## REQUEST

Current Zoning: RE-1 (research district)  
Proposed Zoning: UR-2(CD) (urban residential, conditional)

The petition proposes development of a vacant site in the University Research Park area for up to 82 single-family attached townhomes.

## STAFF RECOMMENDATION

RZ-1

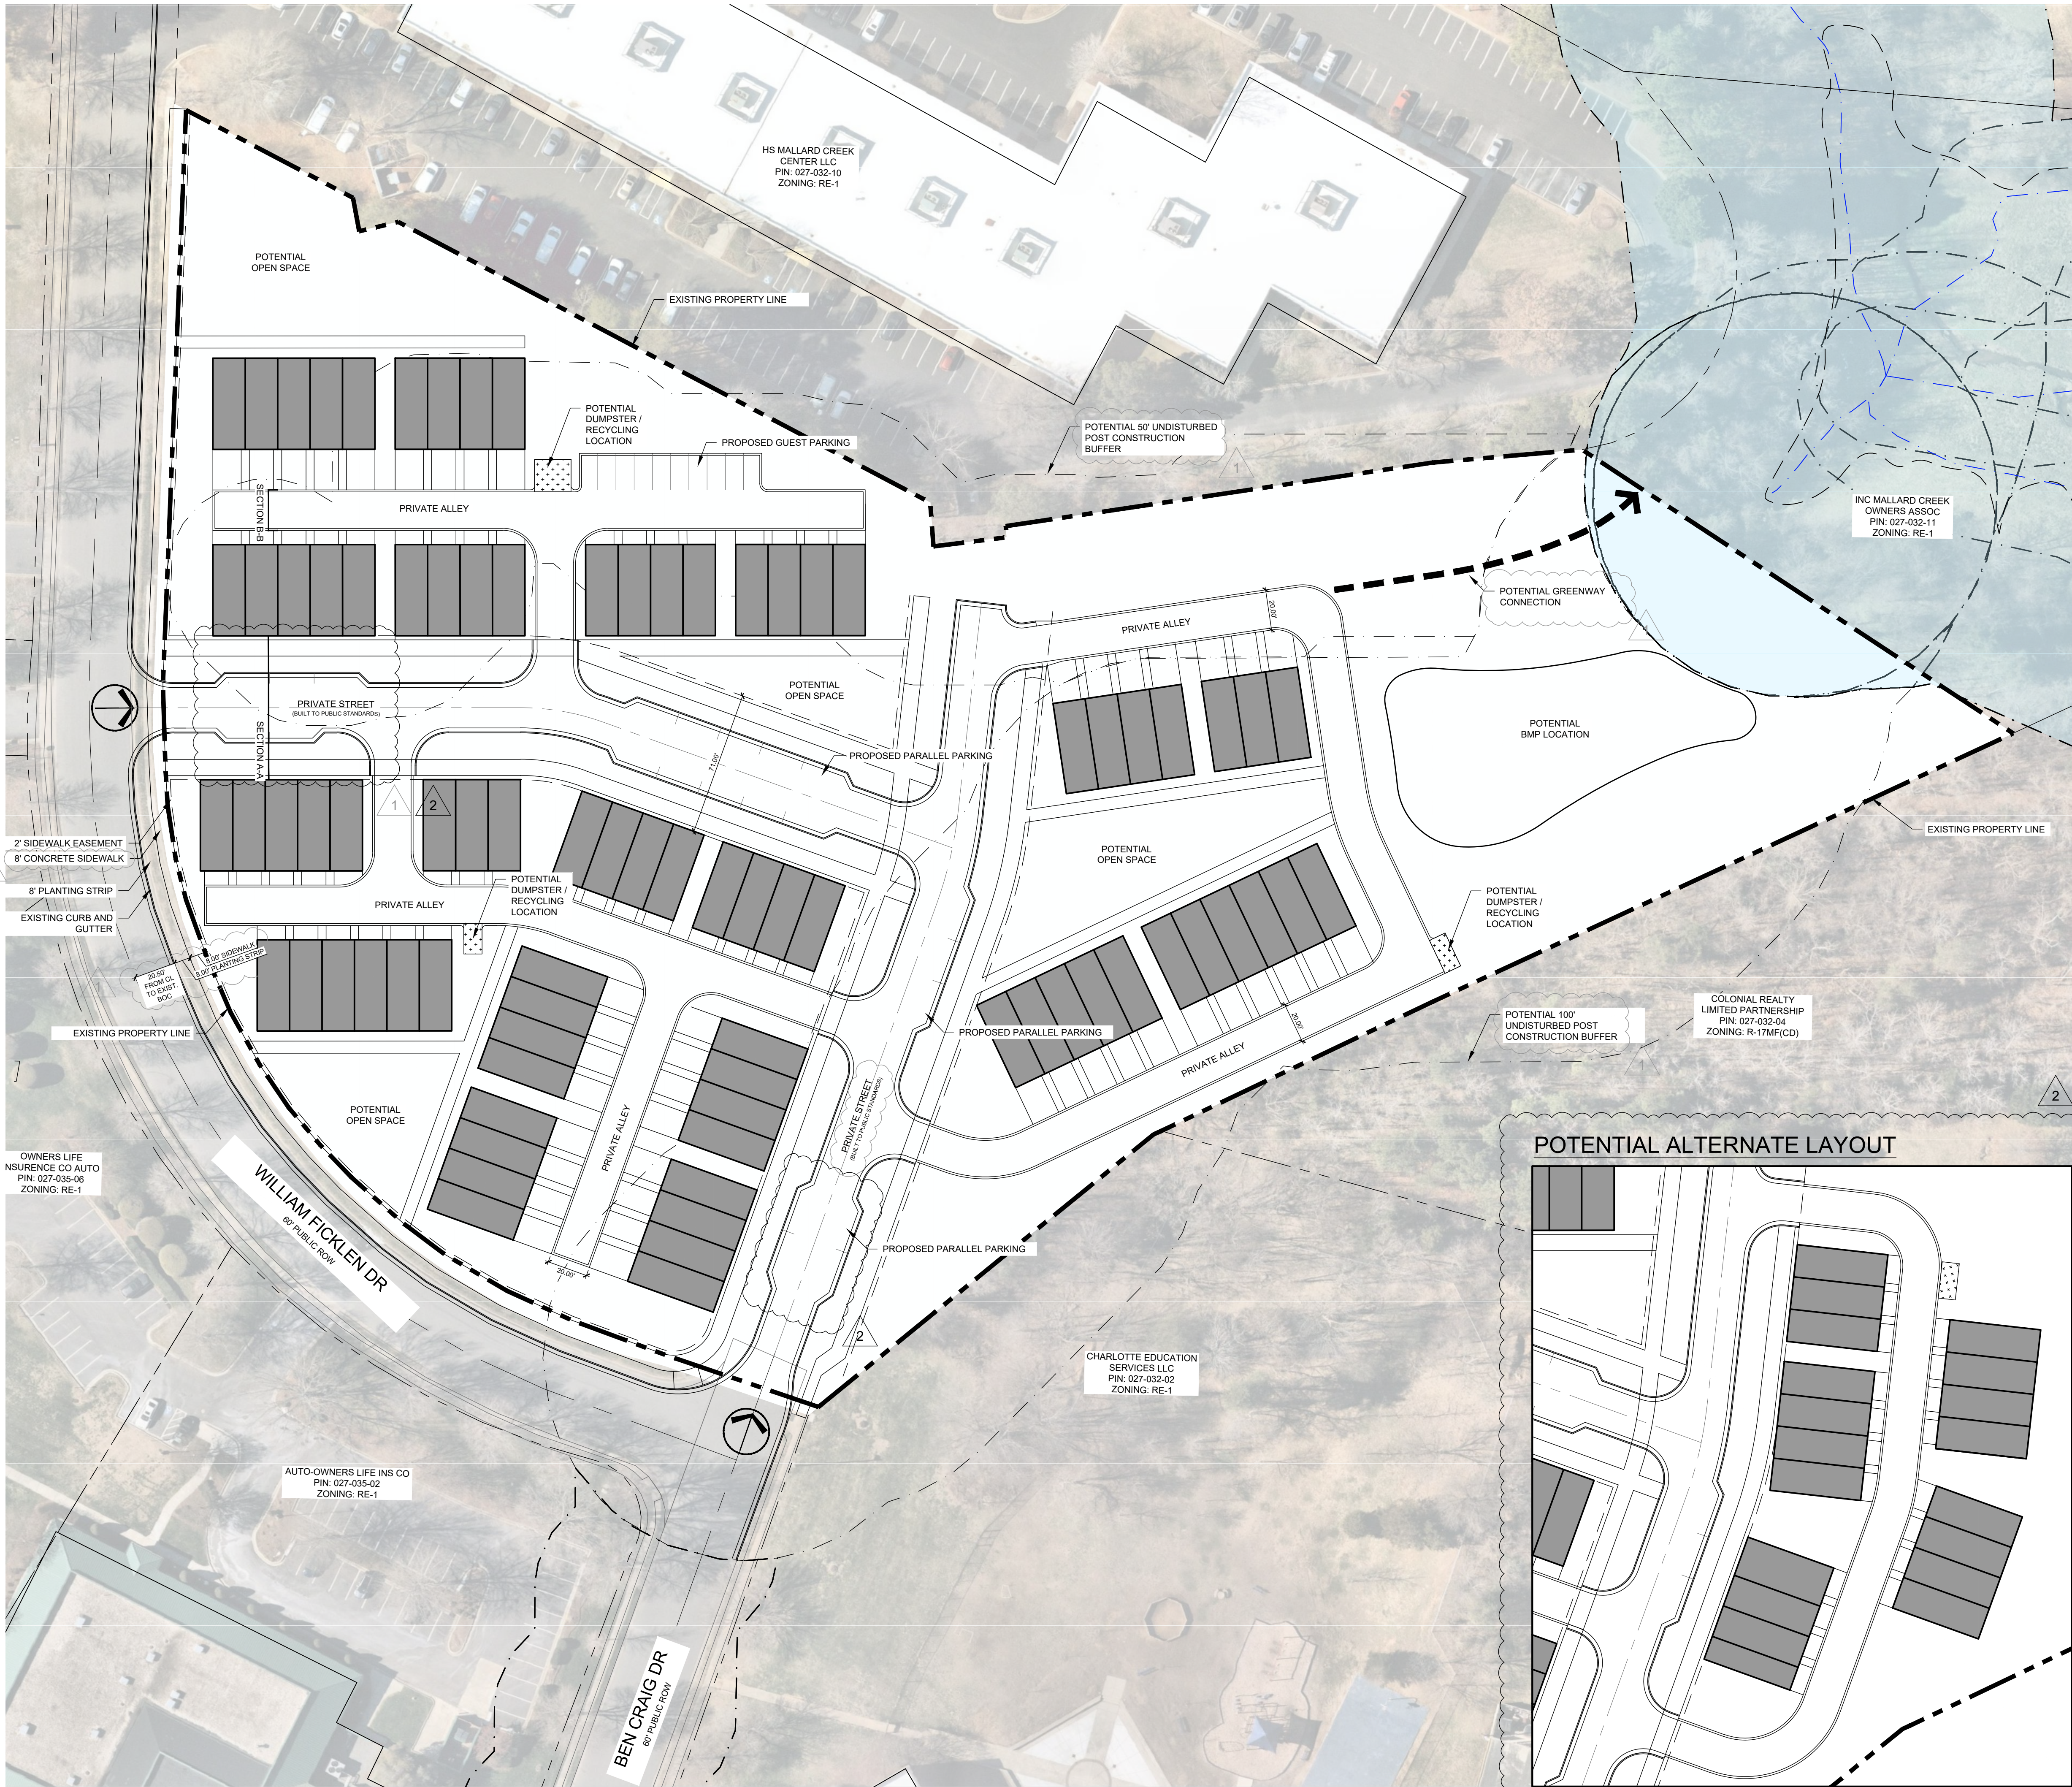
4. ~~Revise site plan to show proper separation between the proposed on-street parking and the intersection. A minimum of 20 feet is required from the curb return to the parking stall.~~ Addressed

6. ~~Provide an 8-foot sidewalk and an 8-foot planting strip along frontage of William Ficklen Drive.~~ Addressed
